Re: Submission to SSD-78996460 – 16-24 Lord Street & 21-27 Roseville Avenue, Roseville

SJB Planning has been engaged by the Eastside Roseville Action Group Inc. (ERAG) to review the proposal and prepare a submission. We act on behalf of ERAG and write to formally object to the proposal.

Submission to SSD-78996460 – 16-24 Lord Street & 21-27 Roseville Avenue,
Roseville

REV. C **DRAWING NO.** SSDA-103

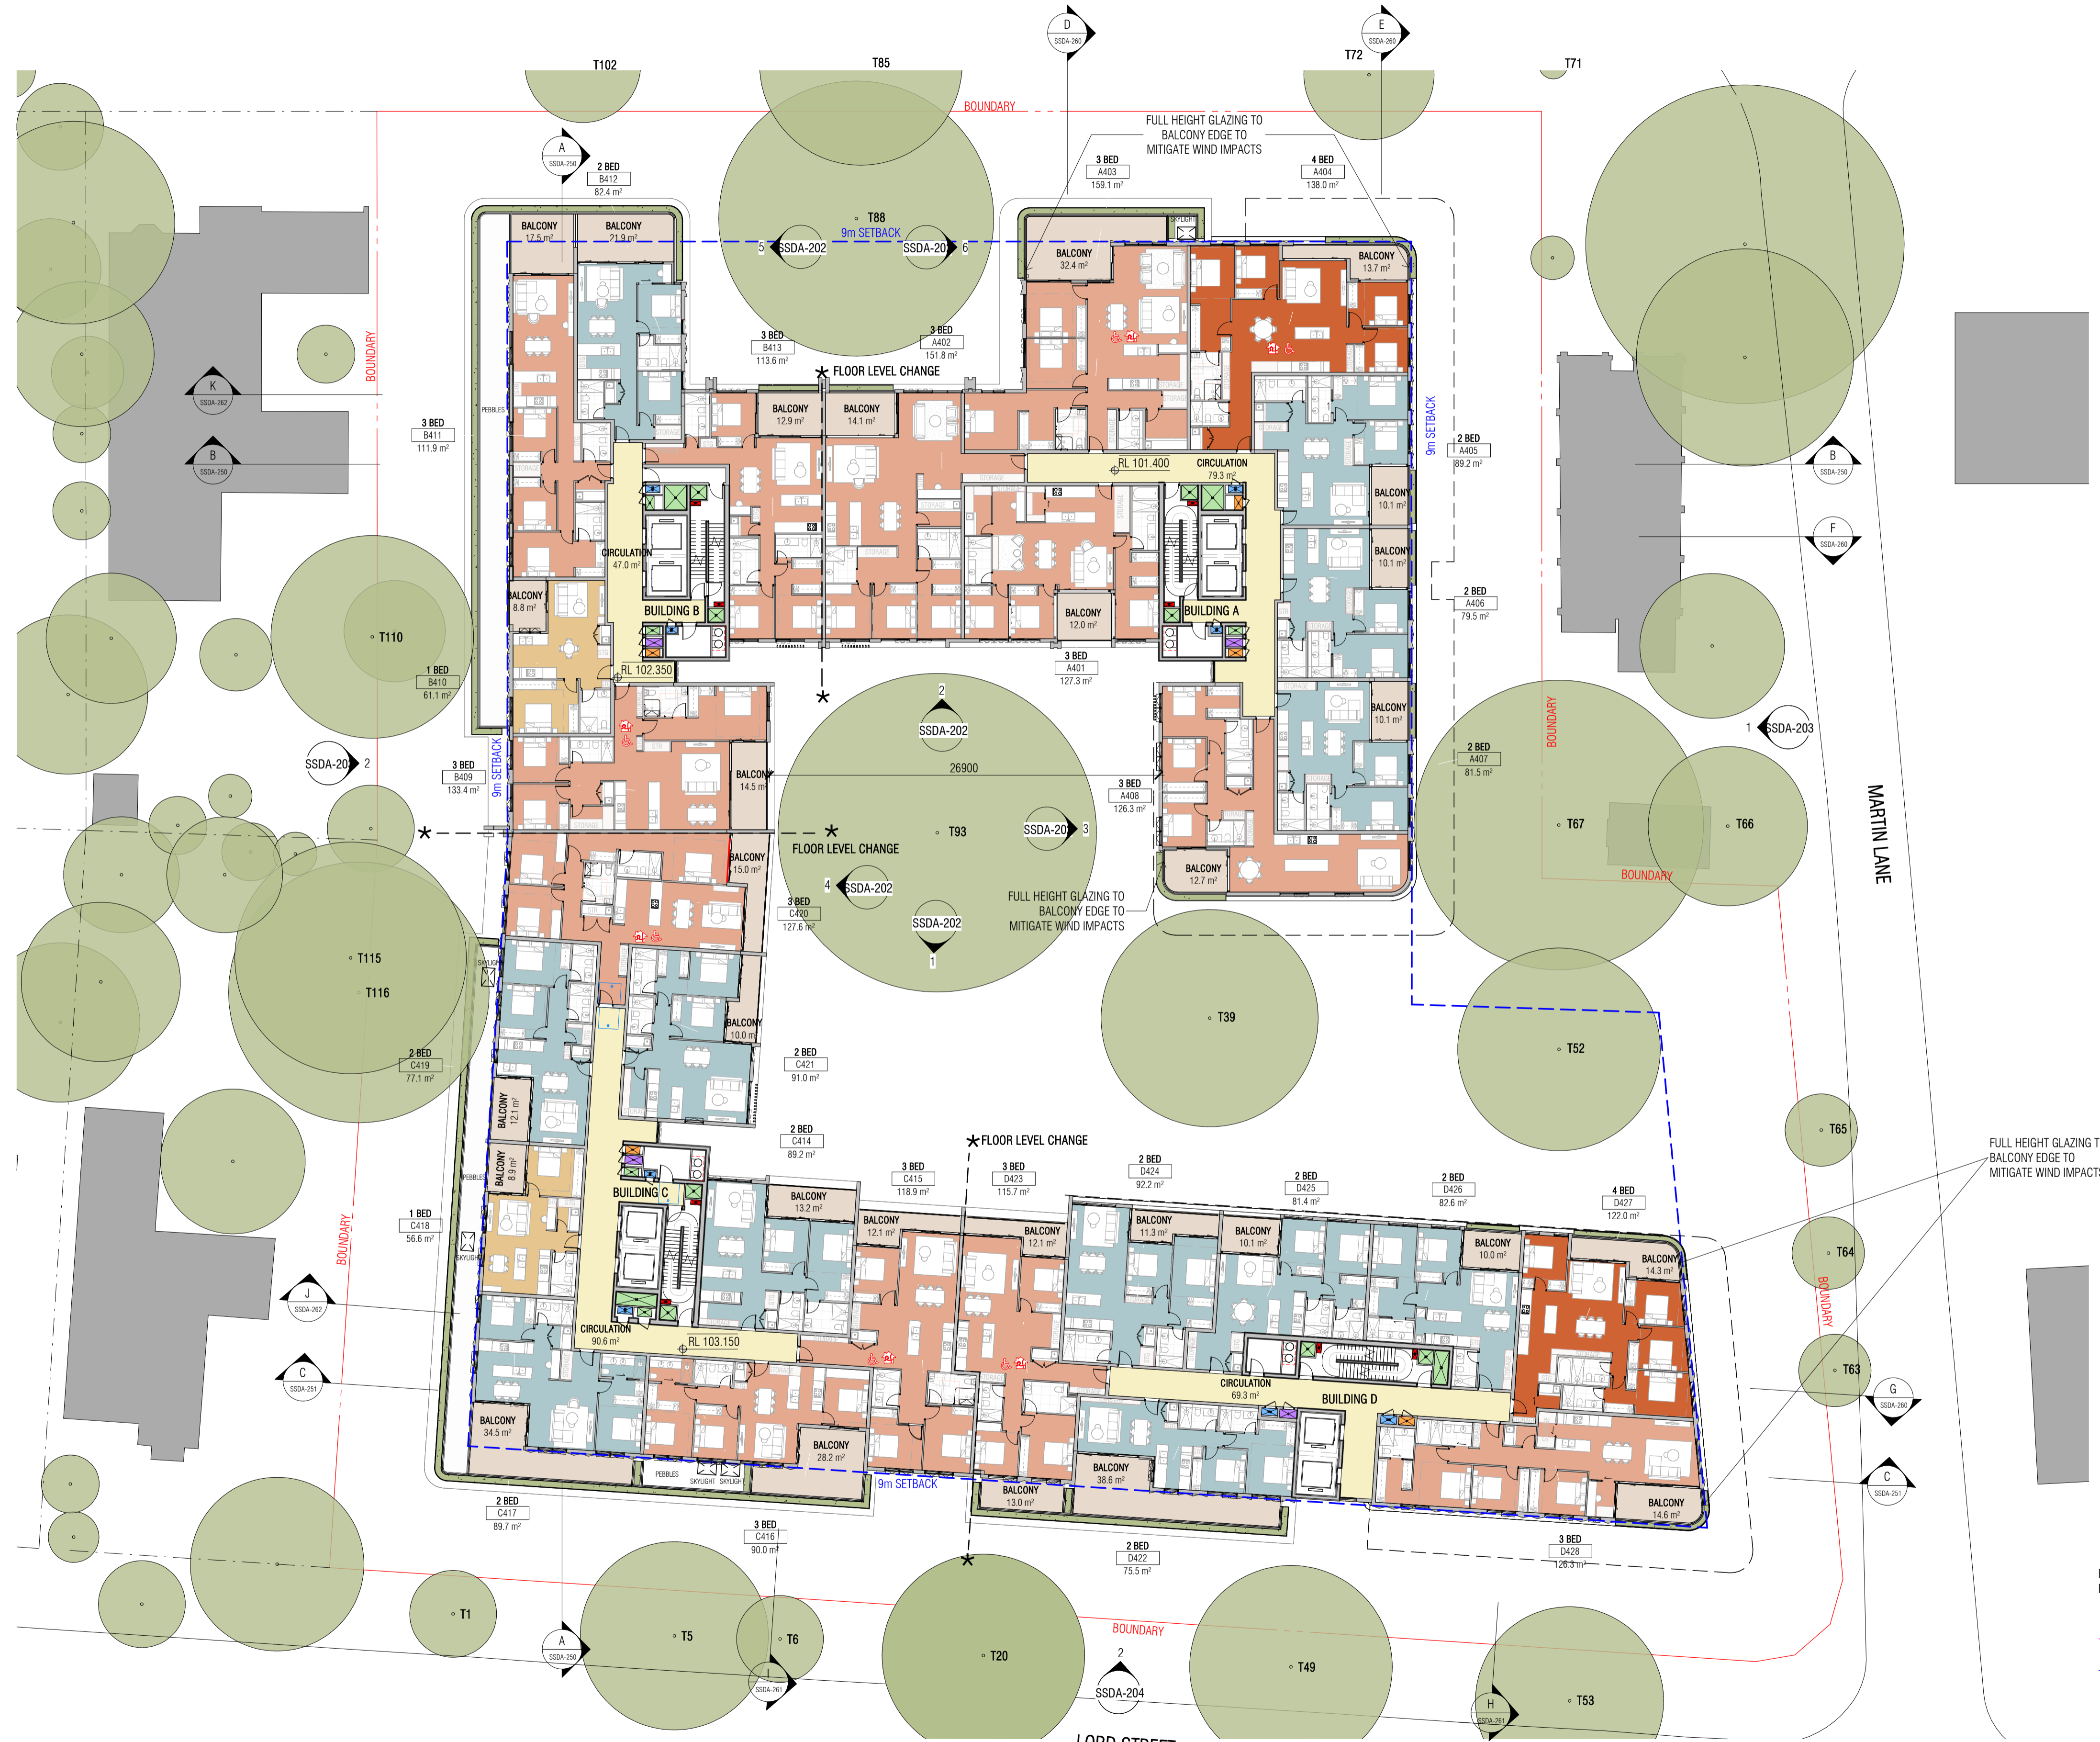
The western elevation presents as an eight storey wall, with inadequate breaking down or separation of the horizontal form to provide visual relief for properties to the west. The footprint also follows the consolidated western boundary at an obtuse angle (less than 180°) which will contribute to an even higher sense of enclosure for adjoining properties.

REV. C
DRAWING NO. SSDA-201

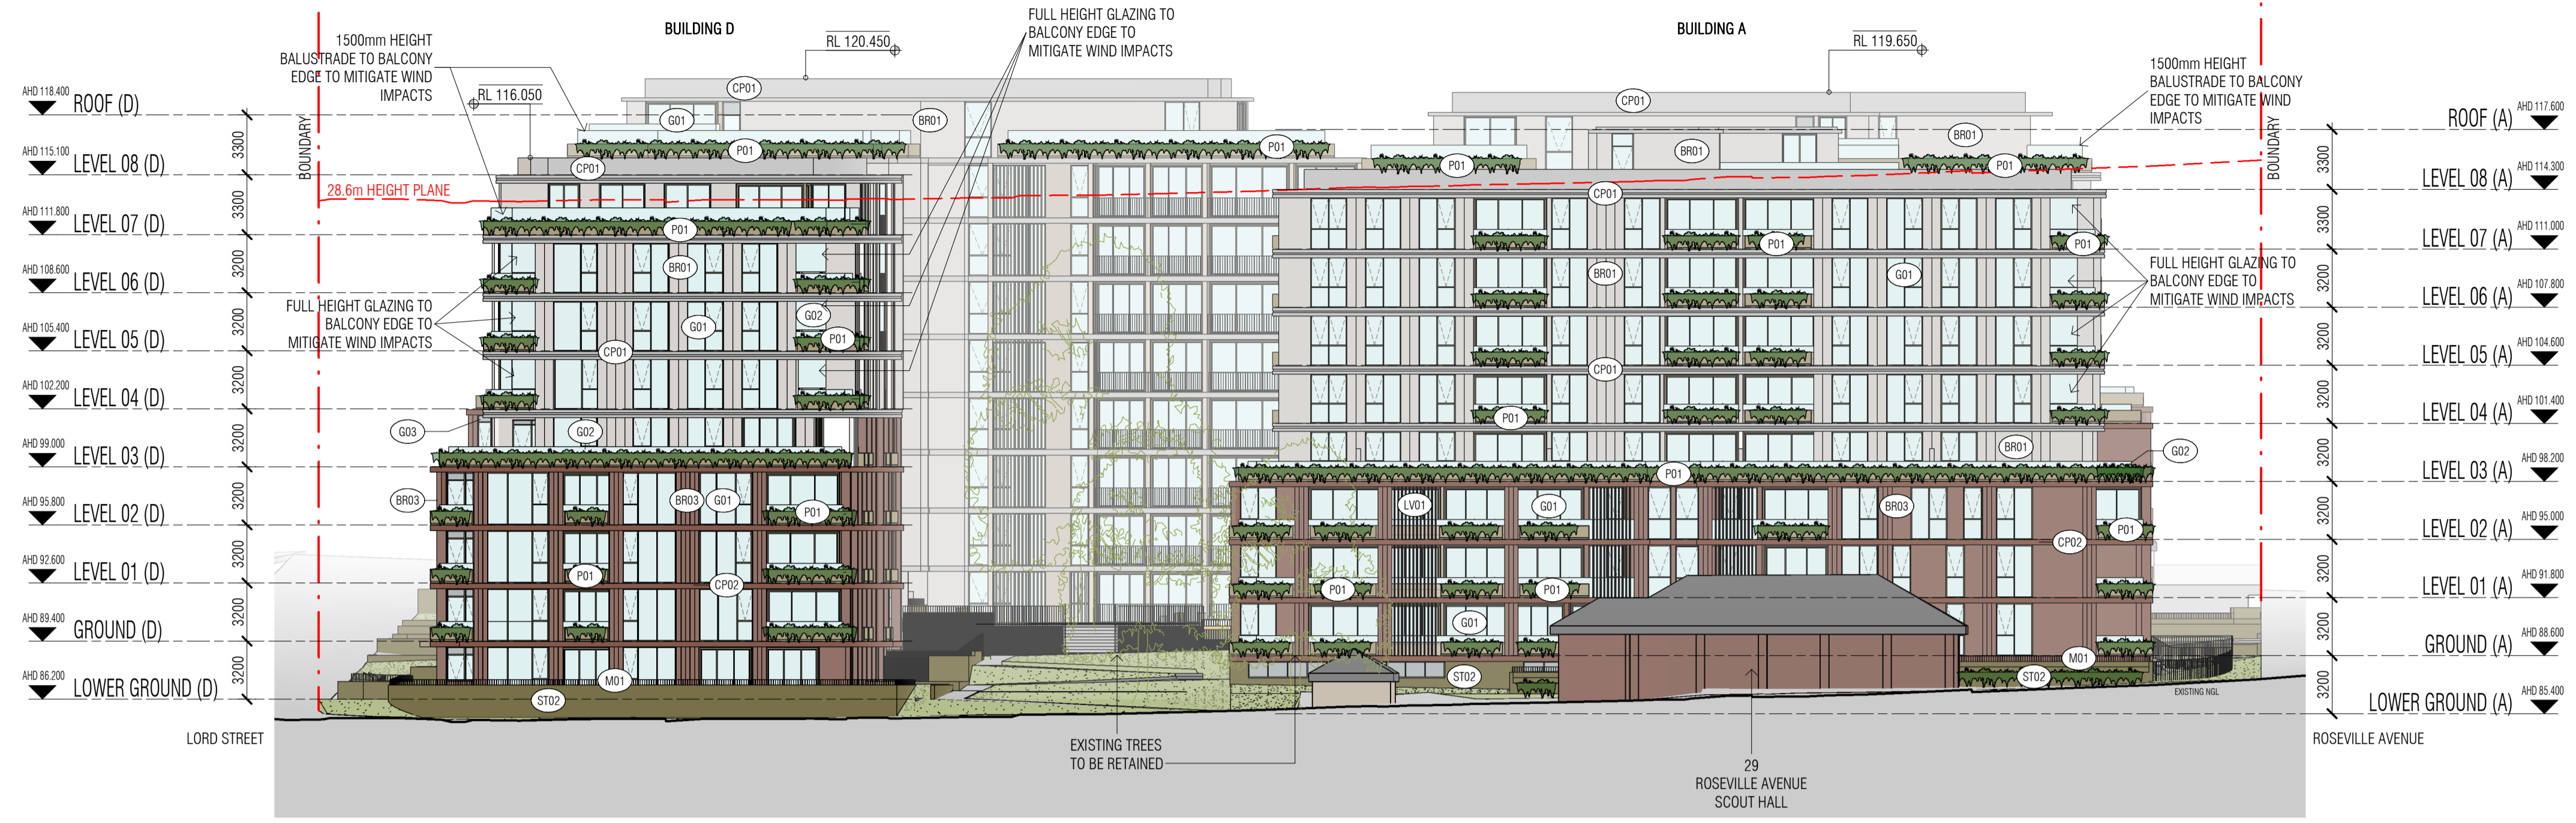
The western podium interface of the proposed building footprint is approximately 88m in length and directly faces low density residential development adjoining to the west. At its upper levels, the western side of the building is approximately 83m in length (refer to Figure 3).

Along its 88m length, the western podium interface presents a minor 3m recess in the centre of the site. This minor element is unlikely to be able to be “read” from the properties and dwellings adjoining directly to the west as they are situated adjacent to the northern and southern portions of the building, not the centre (refer to Figure 4). The western elevation of the upper levels above the podium provides no additional recess other than the 3m upper level setback.
